MEMO

TO: Nell Donaldson
FROM: Mike Farmer
DATE: April 7, 2015
RE: 195 Kennebec Street – site plan review

DESIGNED	ADJ	DATE	11.25.14
CHECKED	ADJ	SCALE	NTS
FILE NAME	SP-M160 DETAILS	JOB NO.	SP-M160
SHEET	C-7.0

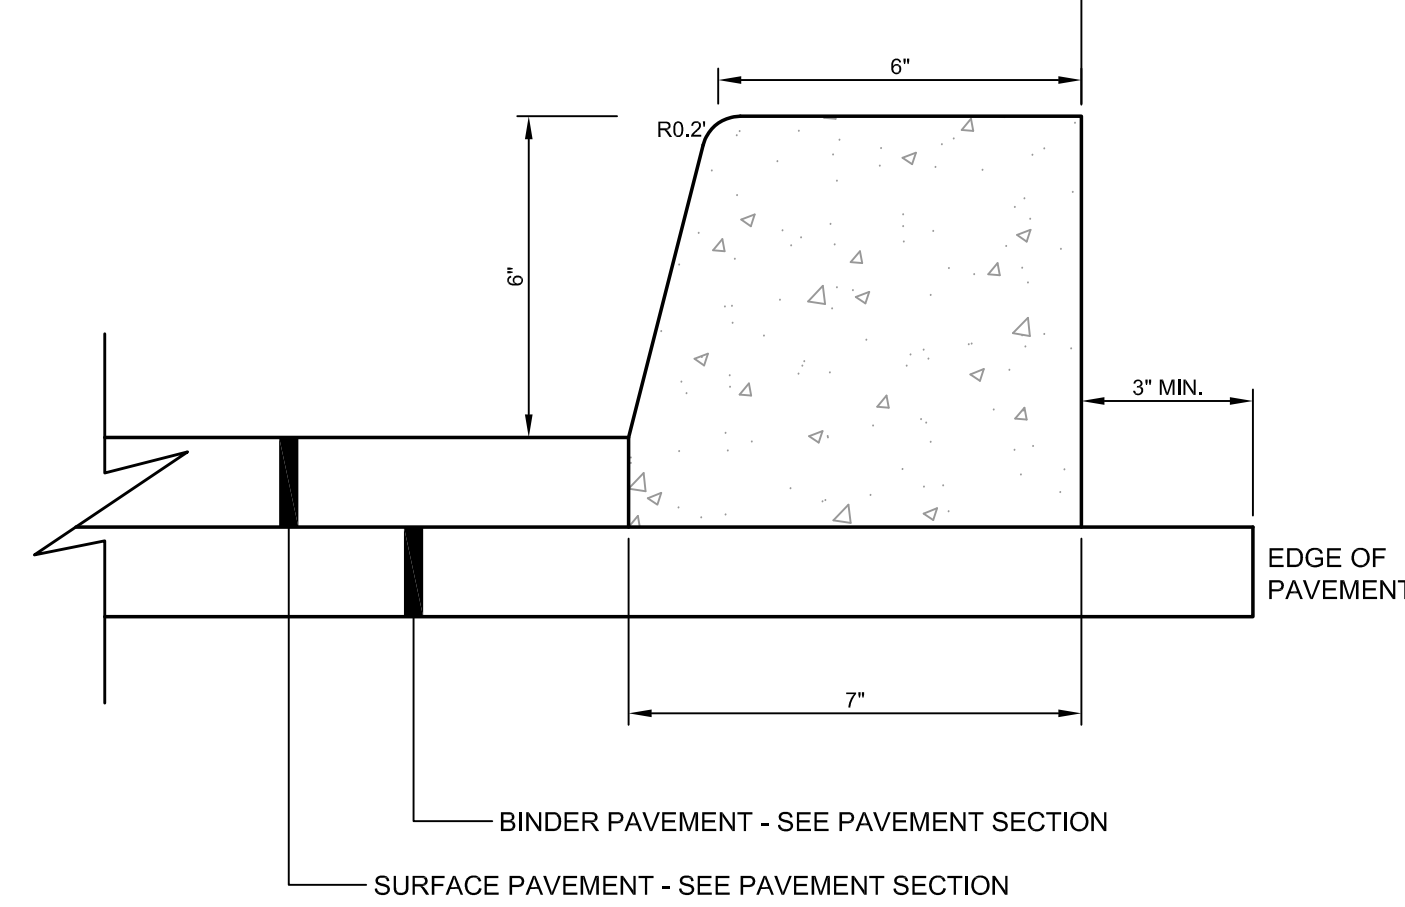
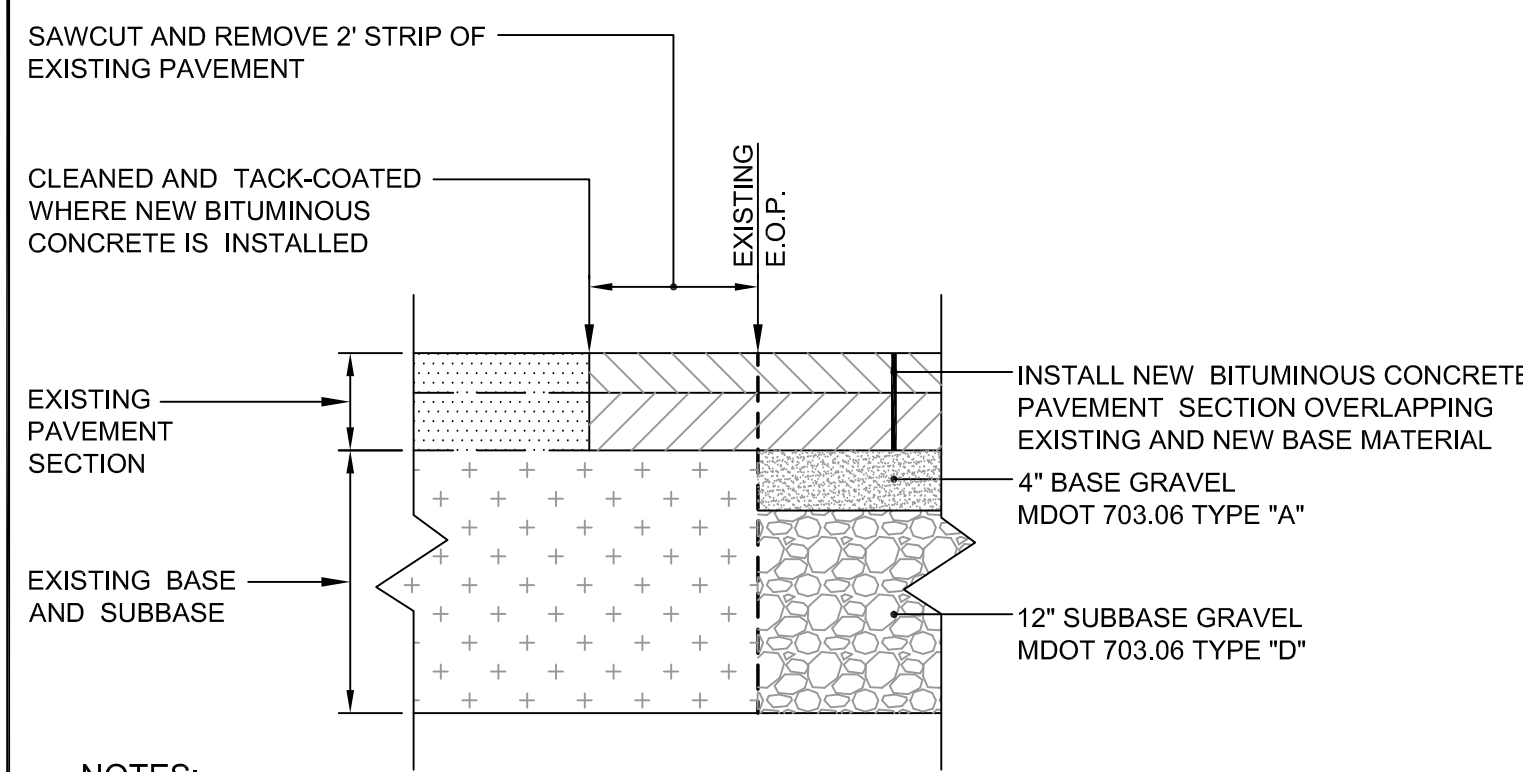
Detail C on plan sheet C-7.0, detail D on sheet C-7.2, and detail E on sheet C-7.2 all should be corrected to show the City standard for depth of base gravel for a brick sidewalk on bituminous base. The depth of gravel should be 10 inches, not 4 inches as indicated in the above referenced details.

PROJECT <b>CENTURY TIRE PLAZA</b> 195 KENNEBEC STREET, PORTLAND, ME	
SHEET TITLE <b>DETAILS</b>		CLIENT <b>NORTHLAND ENTERPRISES, LLC</b>	DRAWN: KCS DESIGNED: ADJ CHECKED: ADJ FILE NAME: SP-M160 DETAILS
REVISIONS		DATE DESCRIPTION	DATE: 11.25.14 SCALE: NTS JOB NO.: SP-M160 SHEET: C-7.1

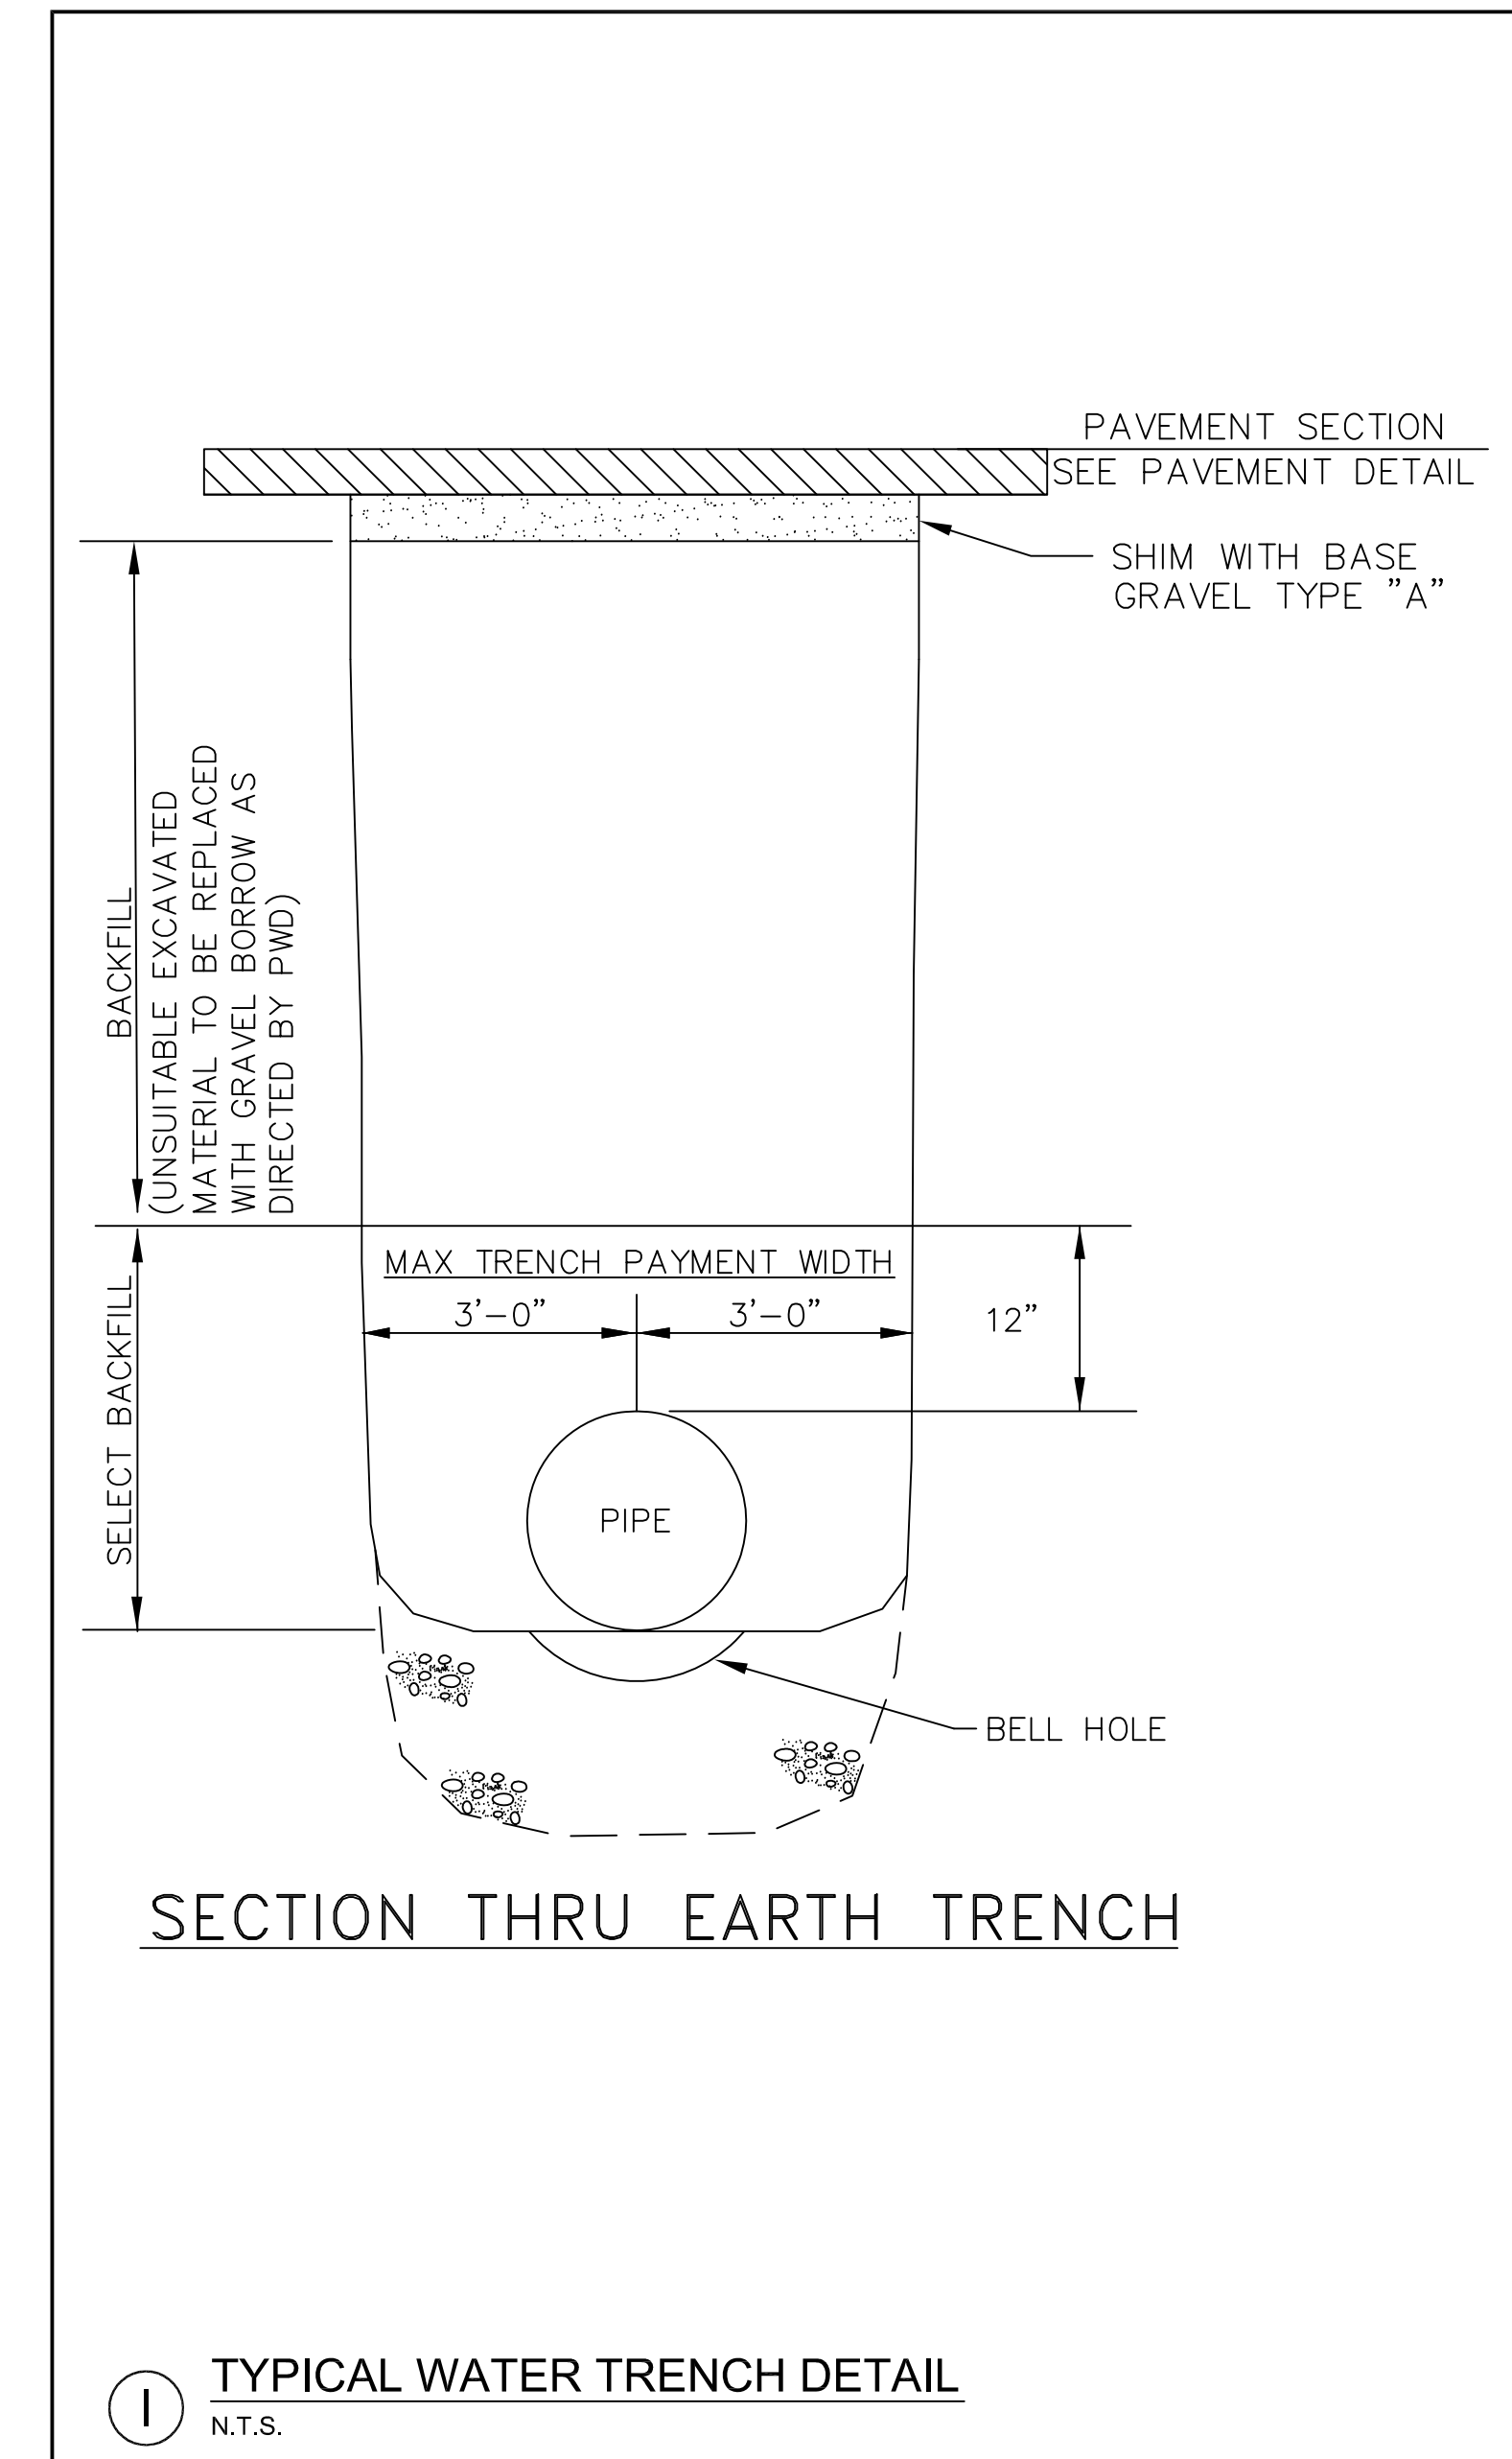
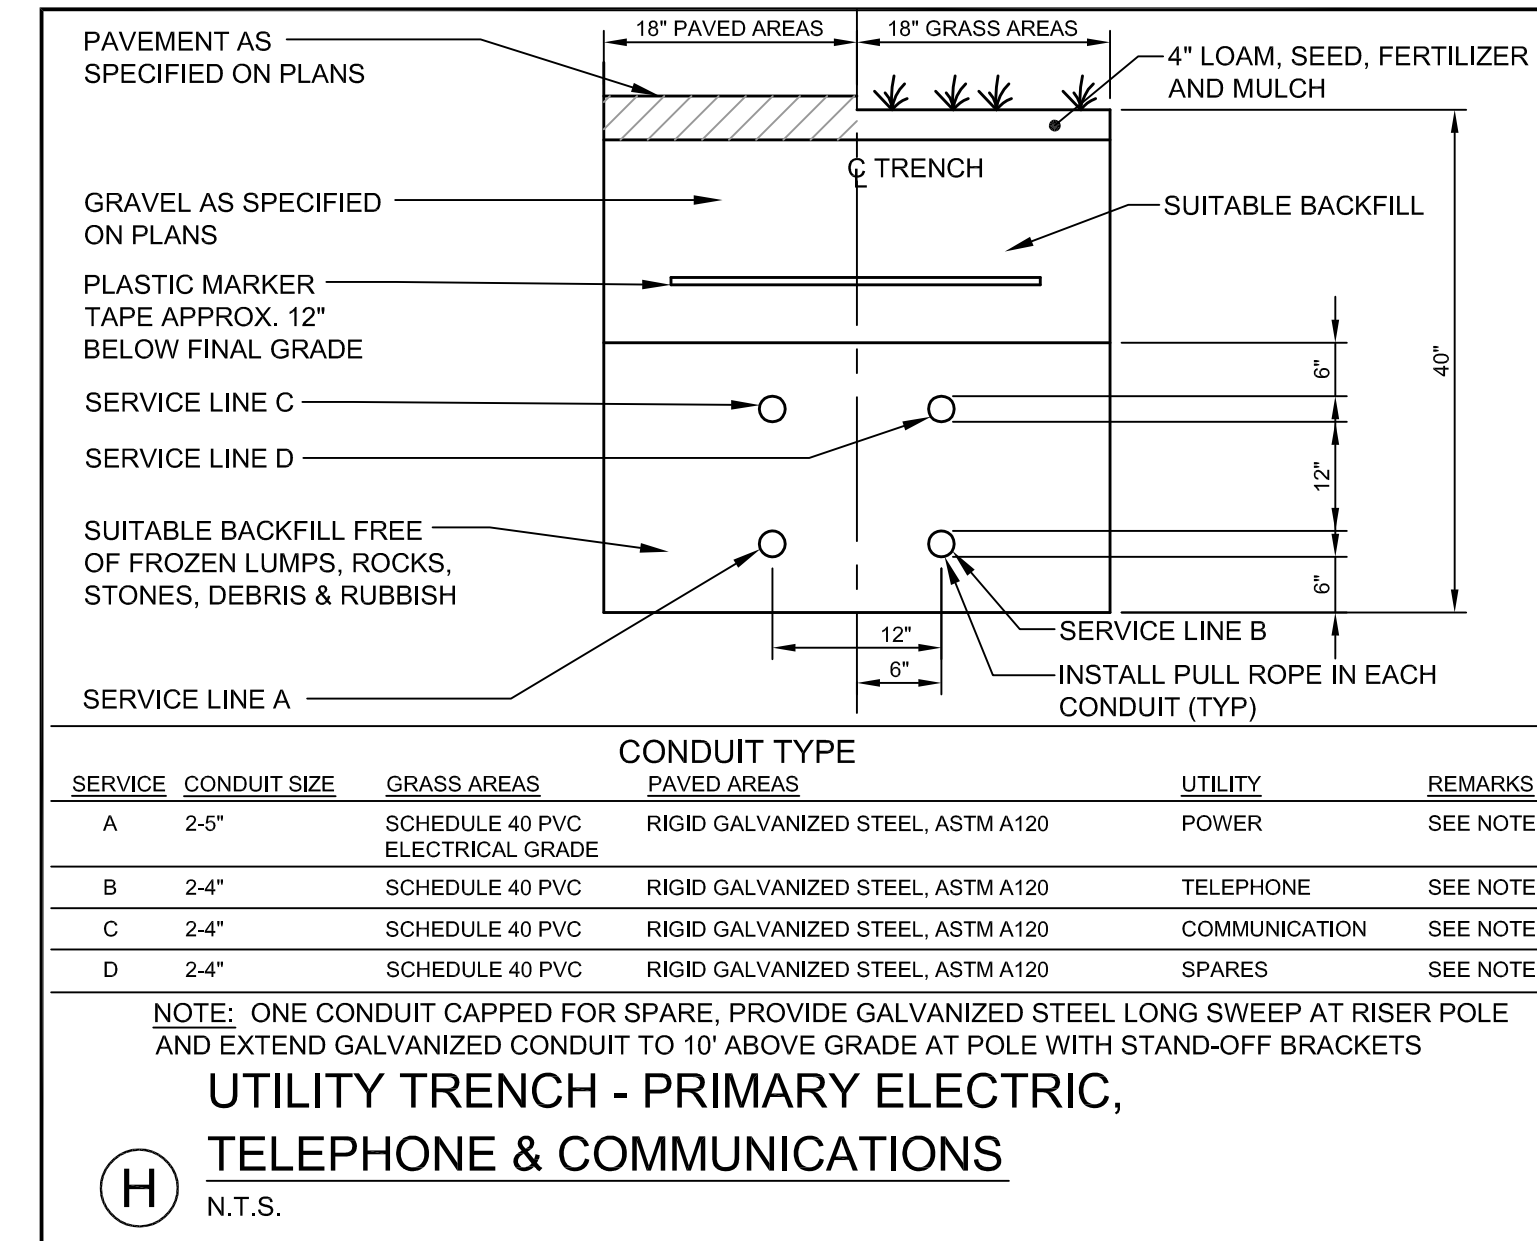
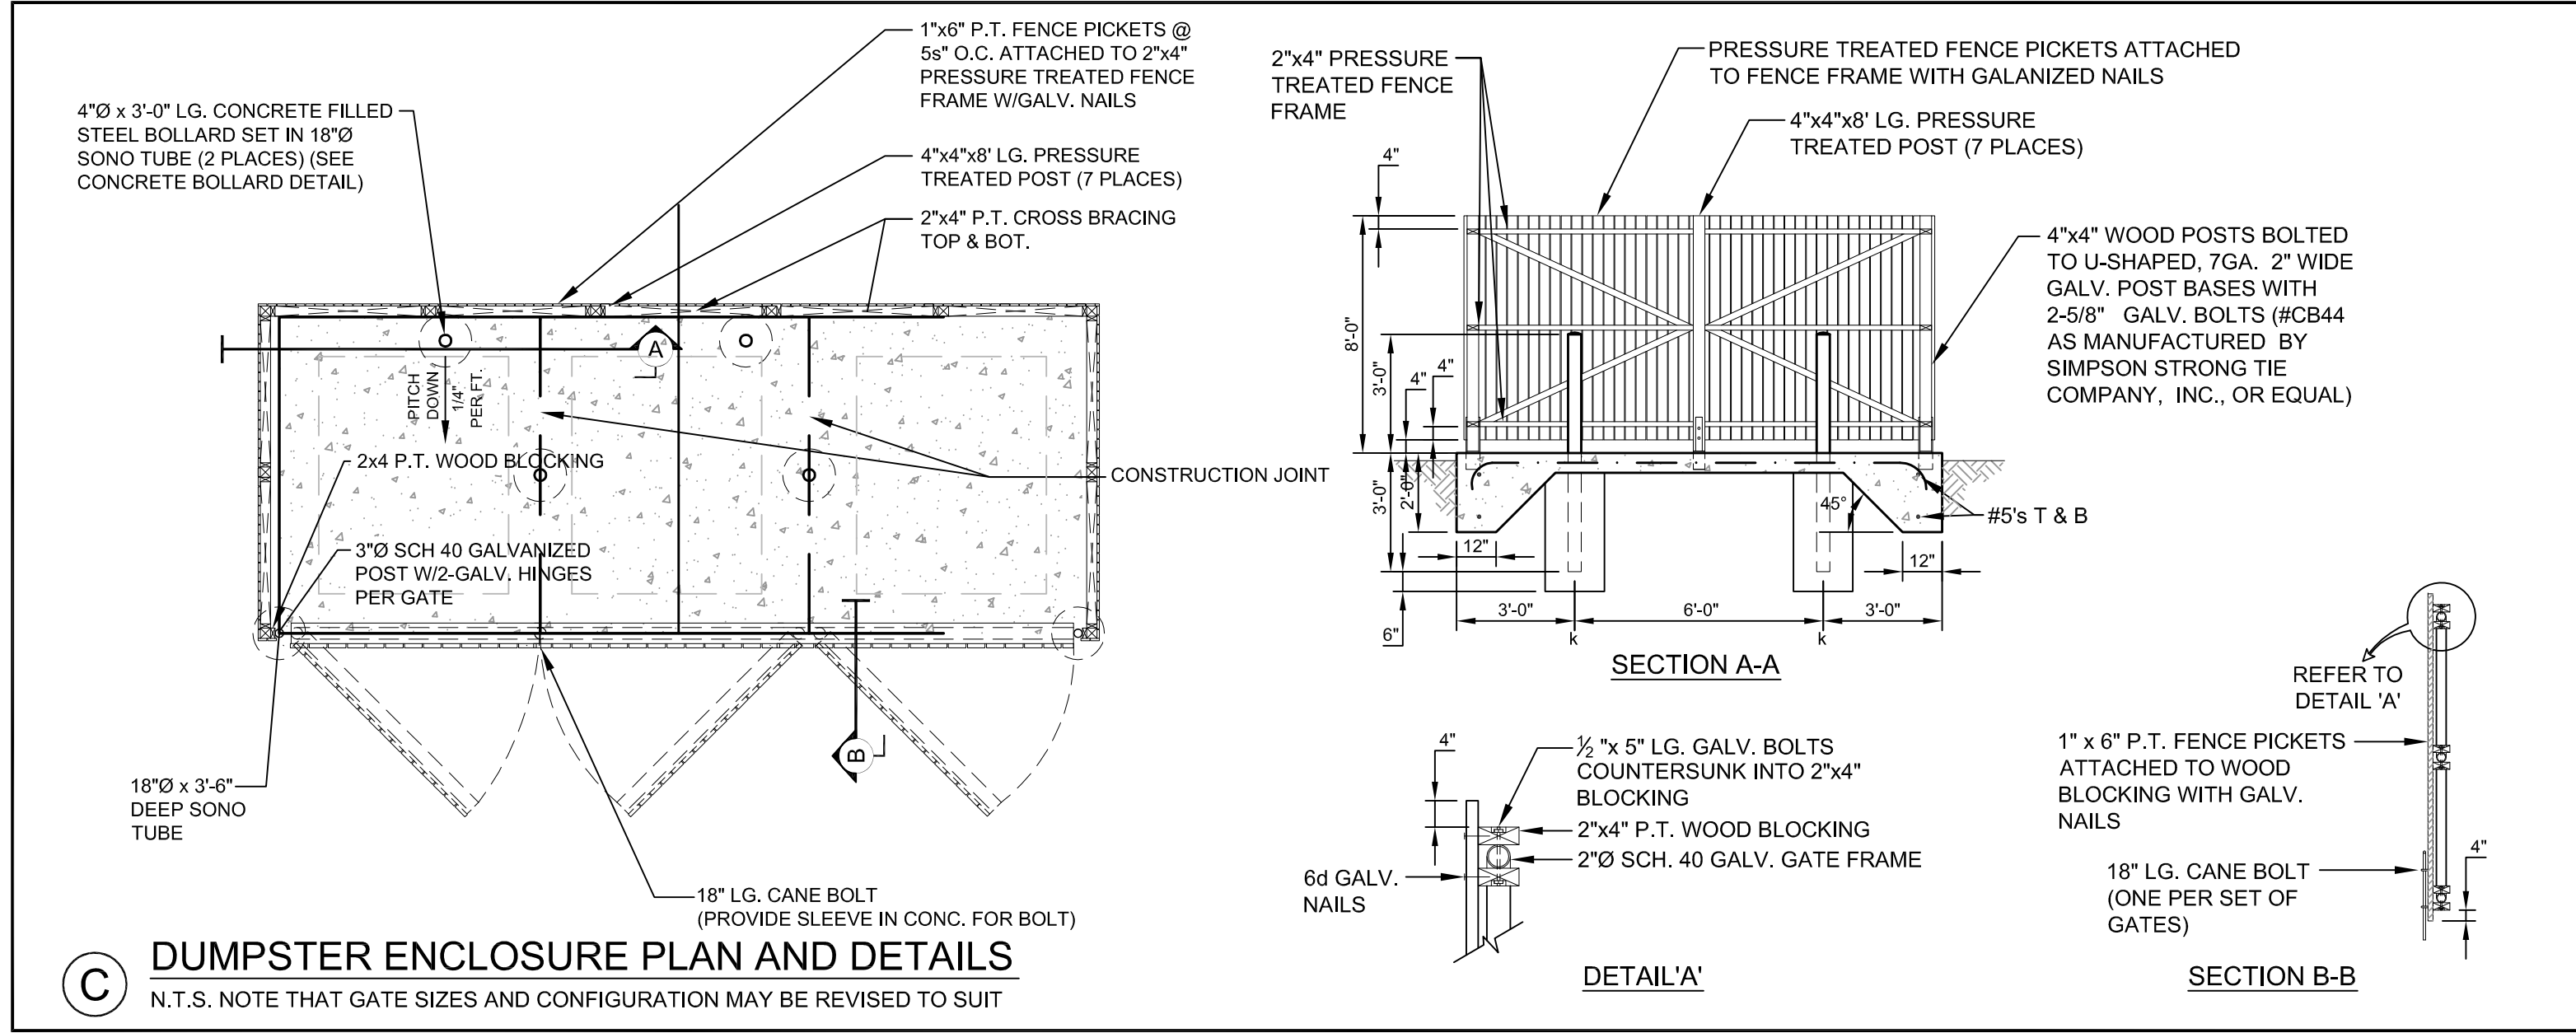
Detail A on plan sheet C-7.1 shows a curb reveal of 6 inches along Kennebec Street. The City standard for curb reveal is typically 7 inches. The curb reveal should be changed to match the City standard unless there are over-riding considerations that require a 6 inch curb reveal. A change to 6 inch curb reveal may require changing the specification for granite curb terminal pieces from 6 feet to 7 feet in length.
